PROJECT TITLE: Church of St. Joseph on the Rio Grande (Tracts 1-A-1)
ZONE MAP: G-11
DRB#: _____ EPC#: _____ WORK ORDER#: _____

Re: Grading and Drainage Plan for St. Joseph's on the Rio Grande (Tract X-1-A1)

RE: Grading and Drainage Plan for St. Joseph on the Rio Grande (G11/D14), Submitted for Site Development Plan for Subdivision, Site Plan for Building Permit, and Grading and Paving Permit Release, Engineer's Stamp Dated 6/7/99.

Re: Church Of St. Joseph on the Rio Grande Conceptual Grading and Drainage Plan

GRADING & DRAINAGE PLAN

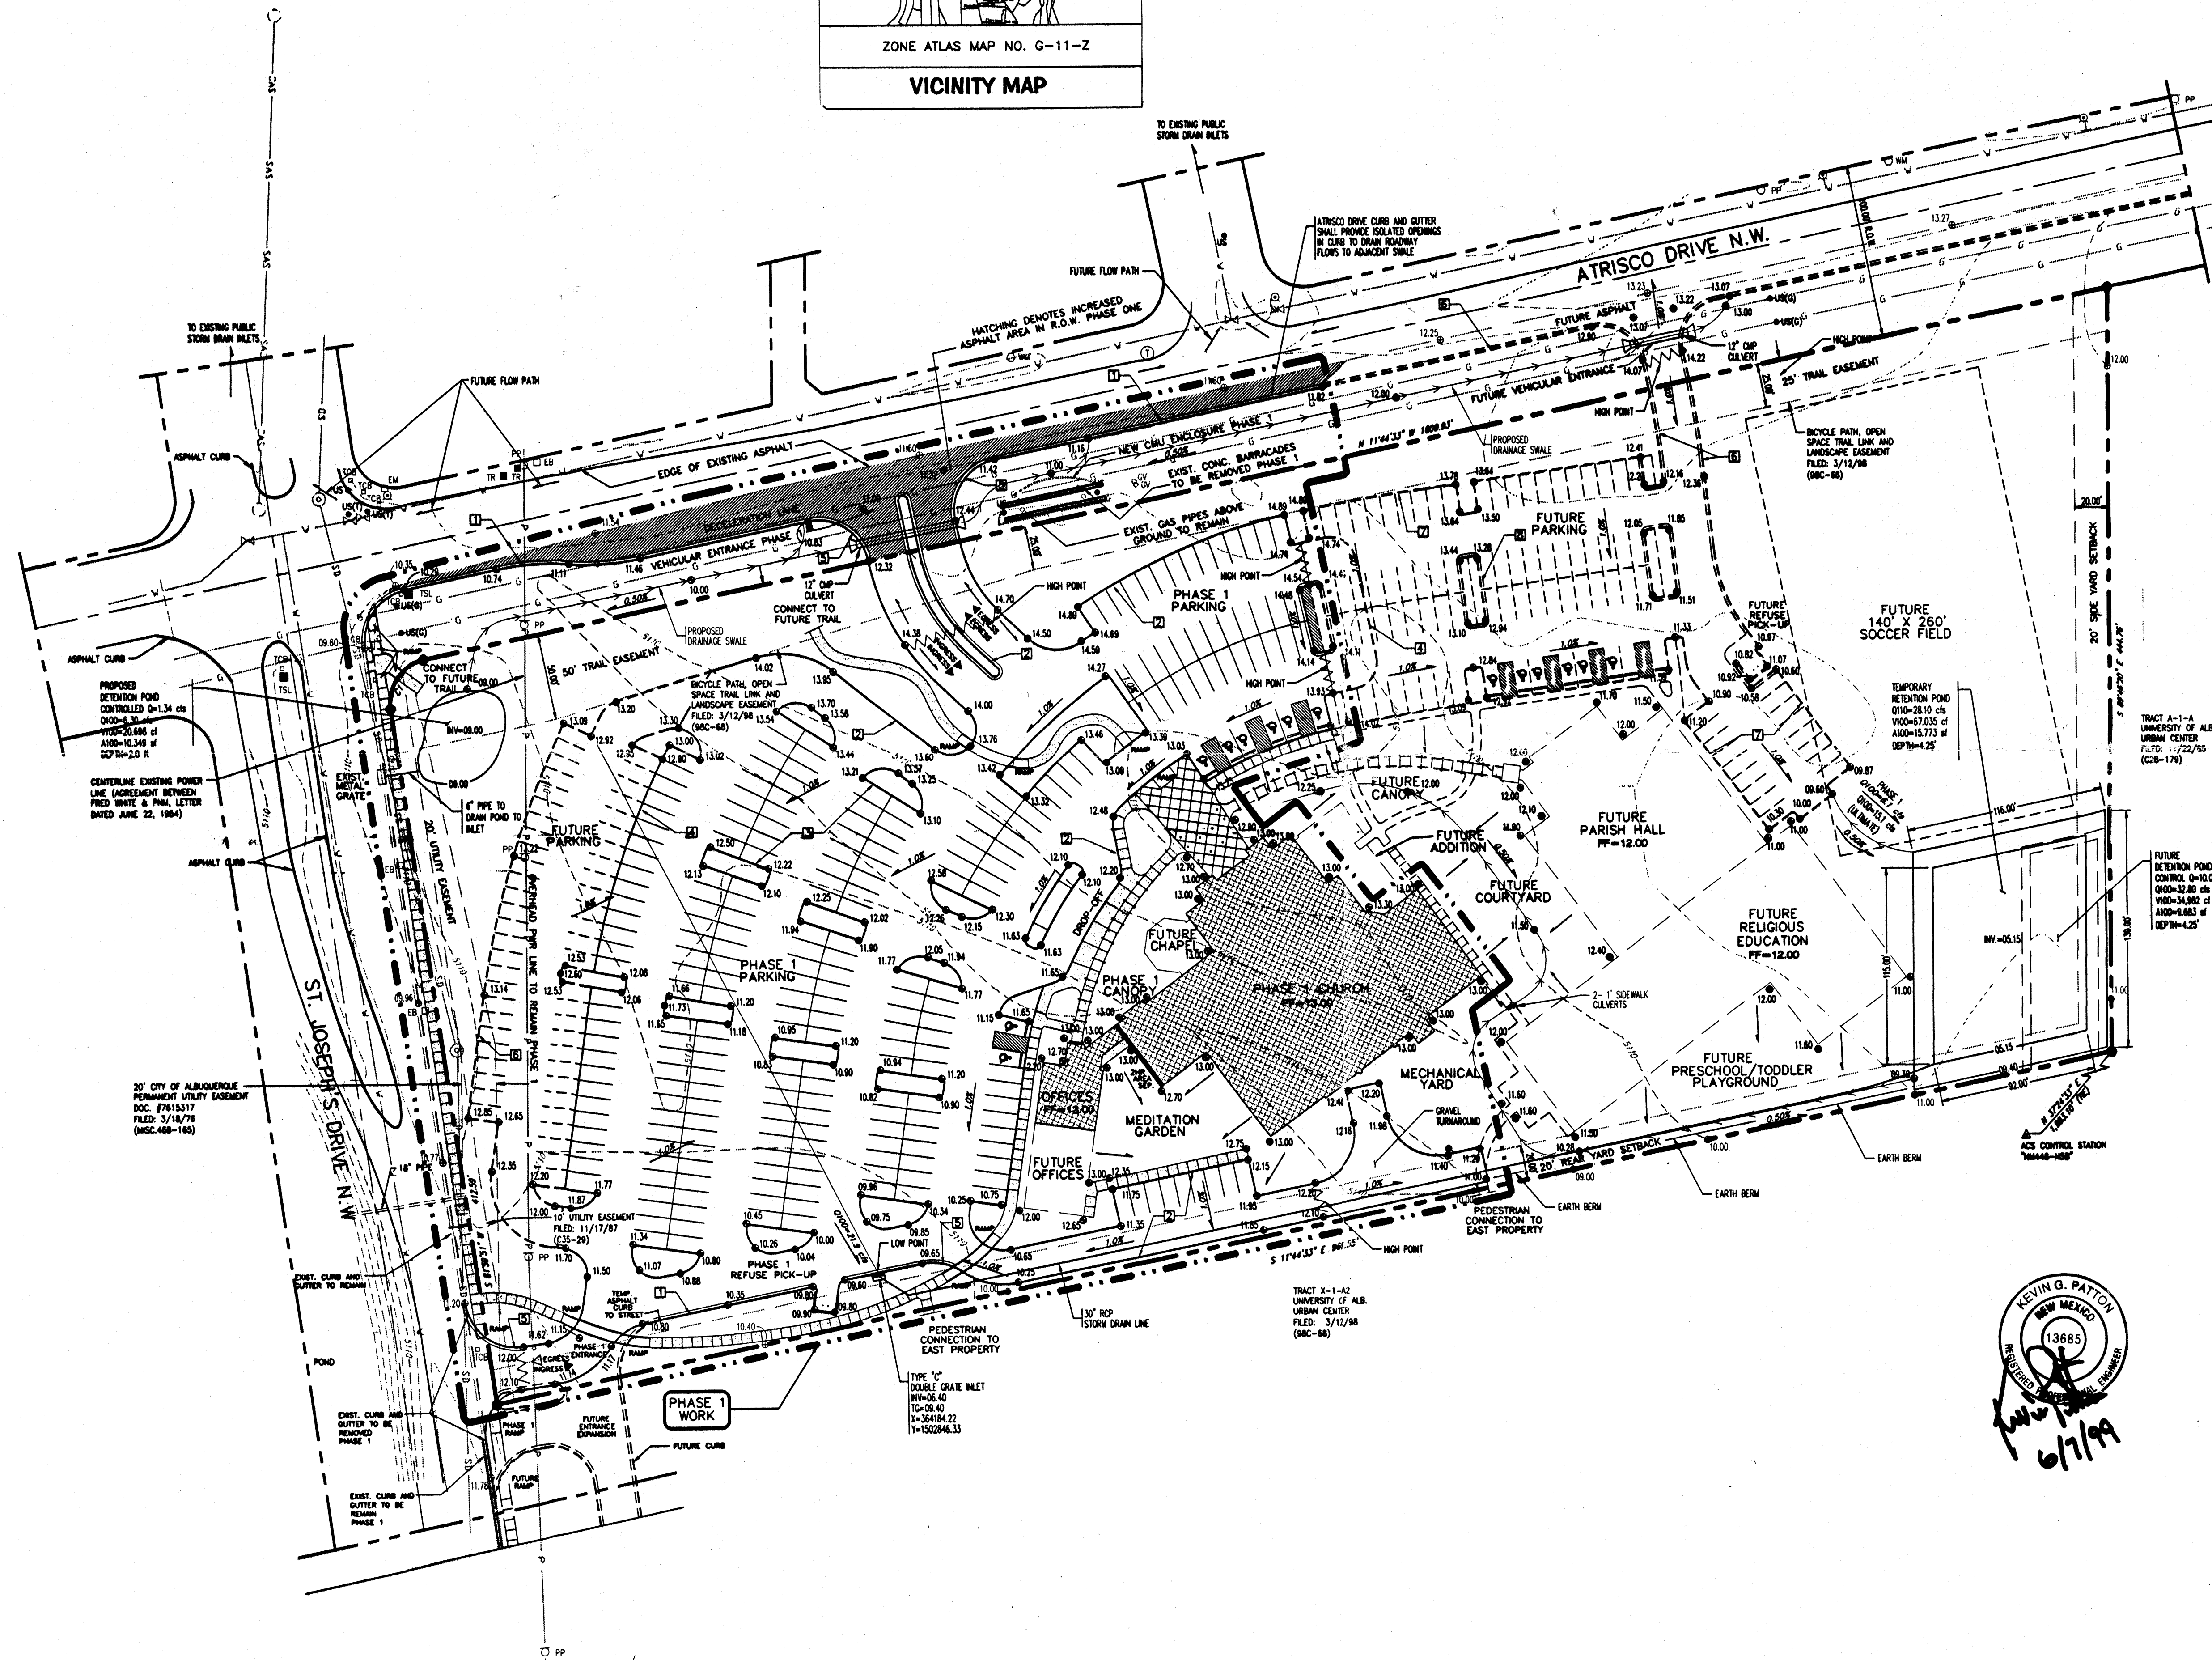
1. The Phase I construction limits were not clear on the plan. How does the runoff from the church reach the temporary retention pond? Are temporary ponds, or berms, needed between phases, or between this tract and Tract X-1-A2?
2. Is the temporary retention pond designed for the 100-year, 10-day storm?
3. The plan shows flow lines for drainage swales, however it appears that the flow arrows are pointing in the wrong direction. Please revise these. Is the 30" storm drain located under the swale on the east side of the tract? How deep is this pipe?

- The phase I construction limits have been clearly labeled on the revised plan. Please note that it is our intent to grade the entire site at this time and that the Phase I construction limits refer to the limits of infrastructure improvements (i.e., building construction, paving, etc.) as approved by EPC.

- The temporary retention pond shown on the drainage plan is designed for the 100-year – 10-day storm event.
- The plan provides a line style for the invert of the proposed swales. This line style appears to indicate a flow course in the wrong direction. I have revised the line style for the proposed swale to correspond with the actual flow direction. There is a private 30" diameter RCP storm drain along the eastern boundary. A portion of this pipe is located under a proposed swale. The depth of this pipe ranges from 3.85 to 6.64 feet deep with a minimum 1.35 feet of cover. Please note that the proposed swale is at a minimal slope and low velocity.

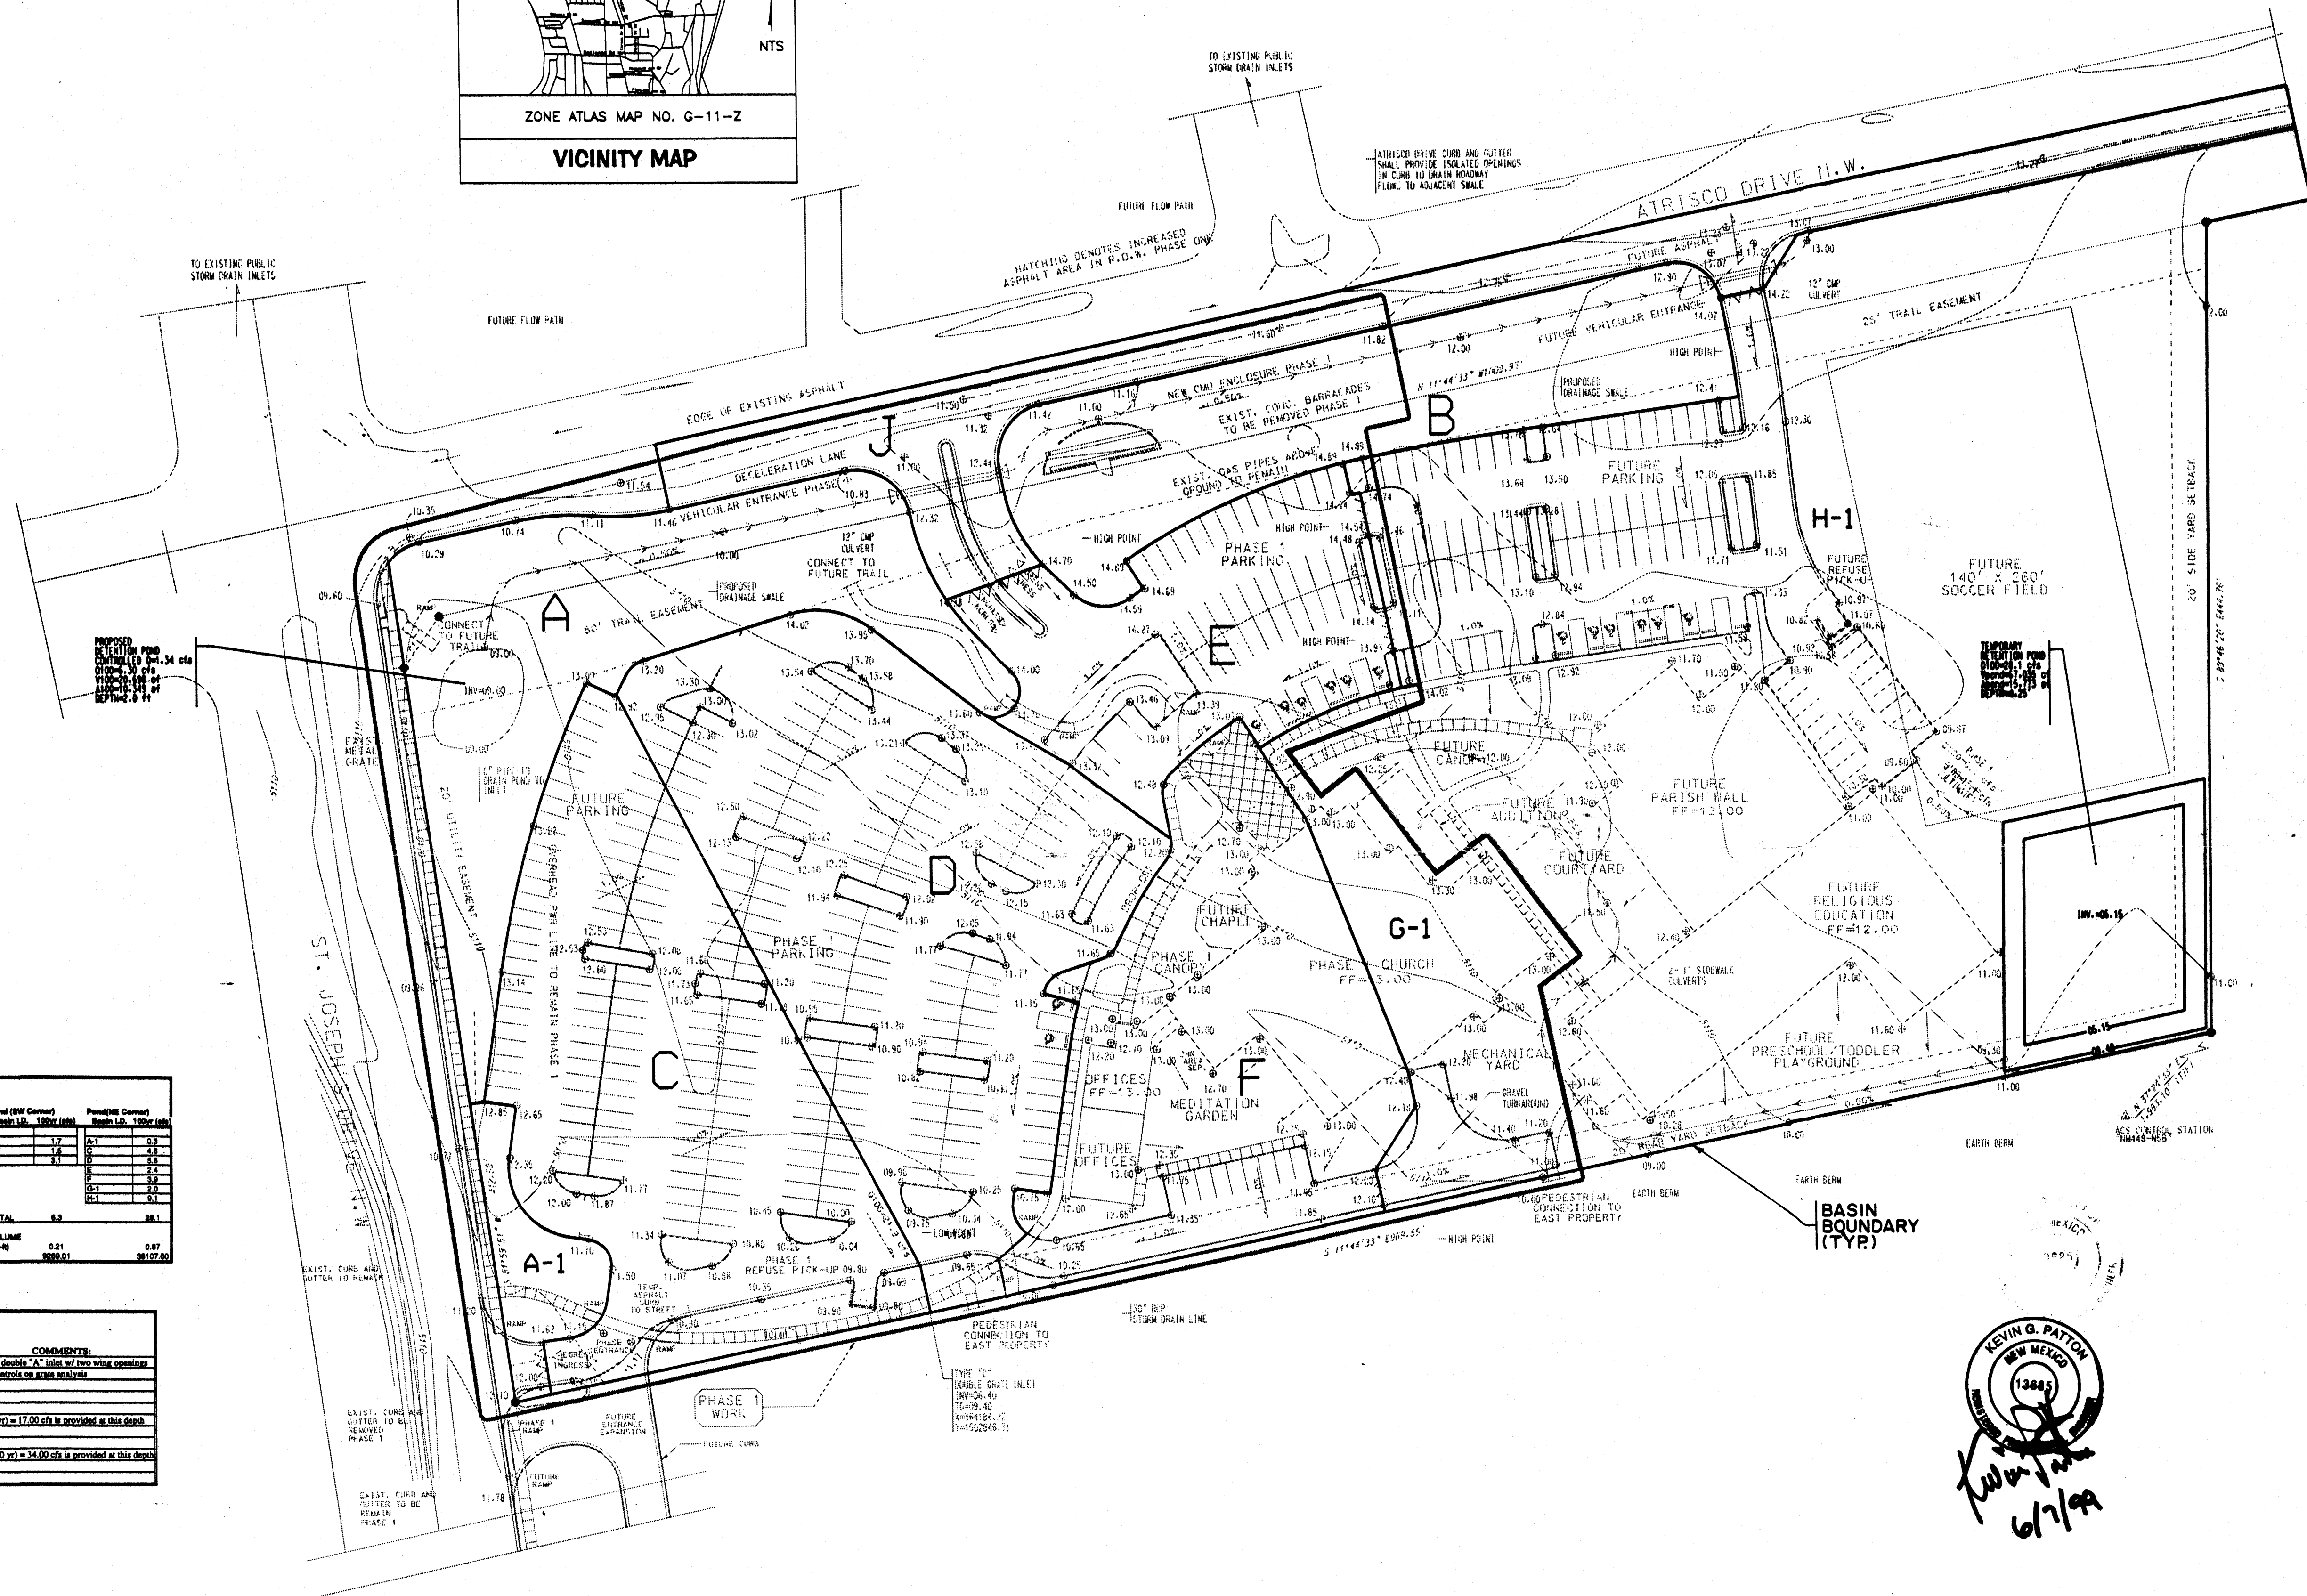
- Before this plan can be approved, even for Site Plan signoff from DRB, written approval of the pond encroachment onto the adjoining property must be provided. Please provide exhibits of the Oxbow DMP to verify what runoff is being accommodated by that project.
- The drainage of Atrisco and St. Joseph R/W (along your frontage) must be addressed with this plan.
